15 January 2013

Further to our meeting last Thursday regarding the planning application for fencing at Nyn Park, Northaw, I would like to reiterate the following points:

TITLE
Proposed Boundary Fence (60f6)

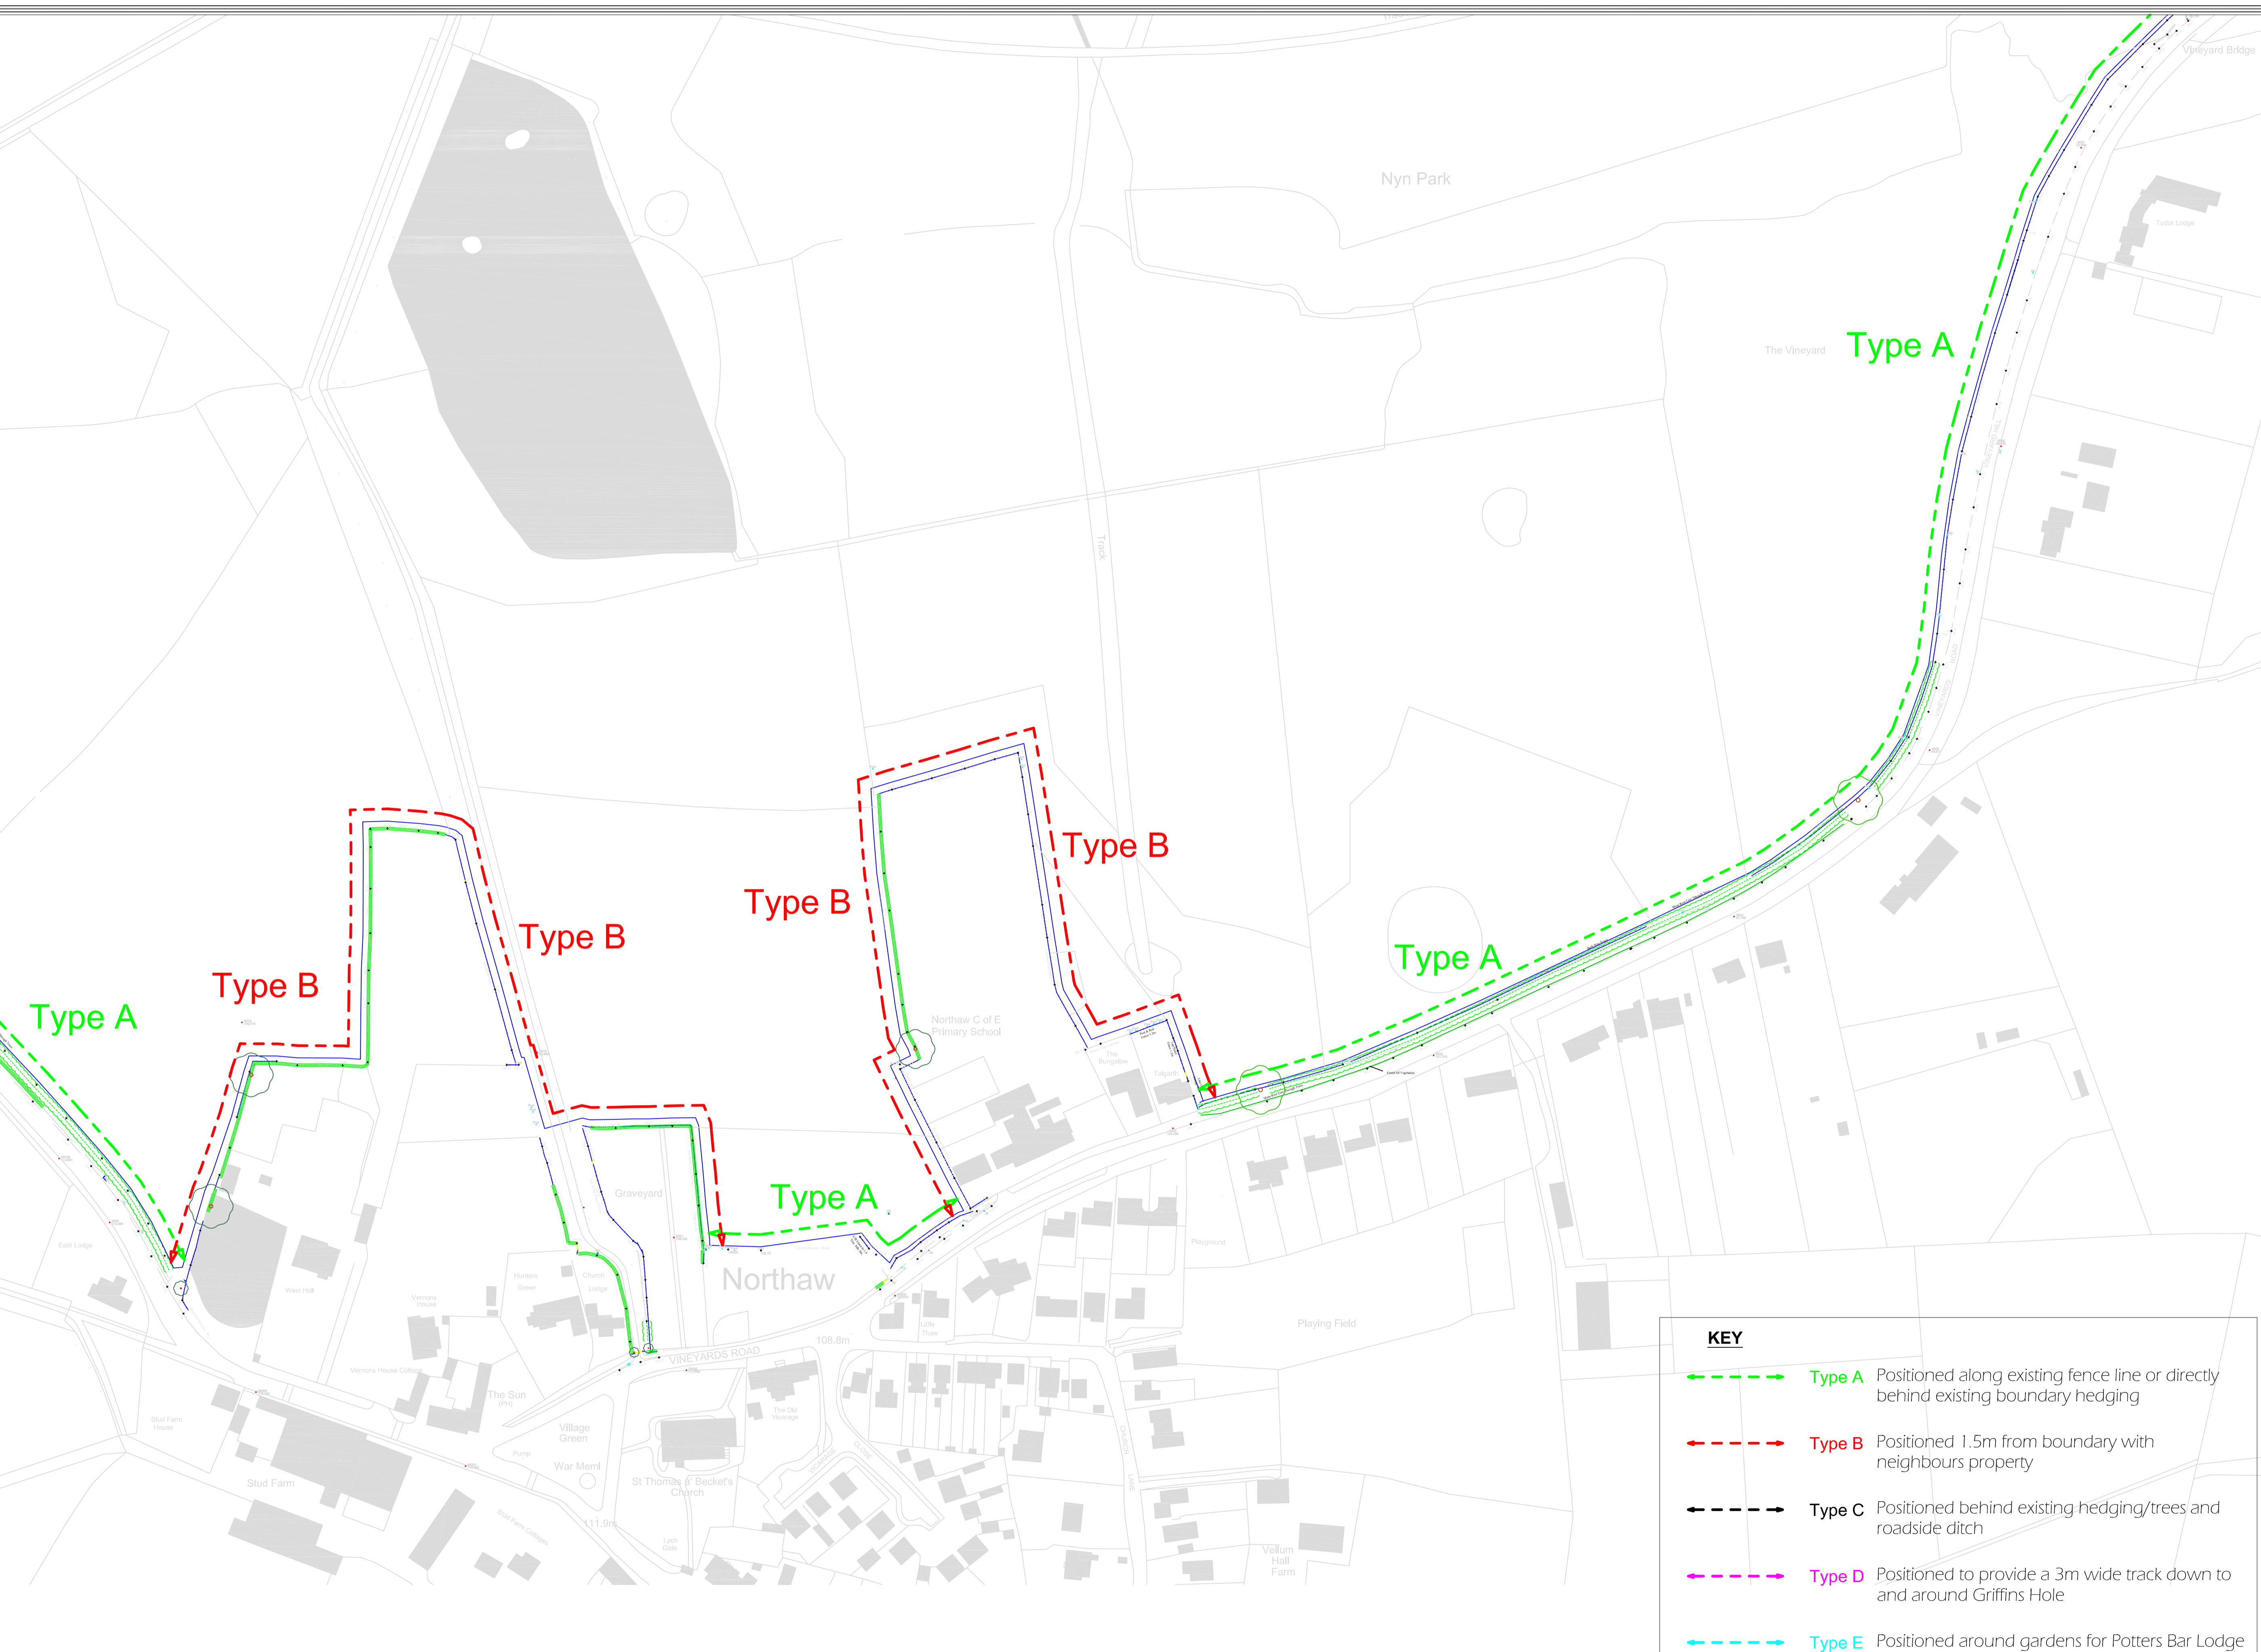
1. We would need a space of at least 3 metres between the fence and our hedge in order for us to cut it by tractor as this is a particularly substantial established hedge.
2. We request that the fencing be no taller than the existing hedge particularly where the cottage forms the boundary. It would feel very claustrophobic if the fence were to be visible from the rear windows where it would be close to the property.
3. We would also ask consideration to be given to the wildlife that has had the freedom to roam in the Park in the past.
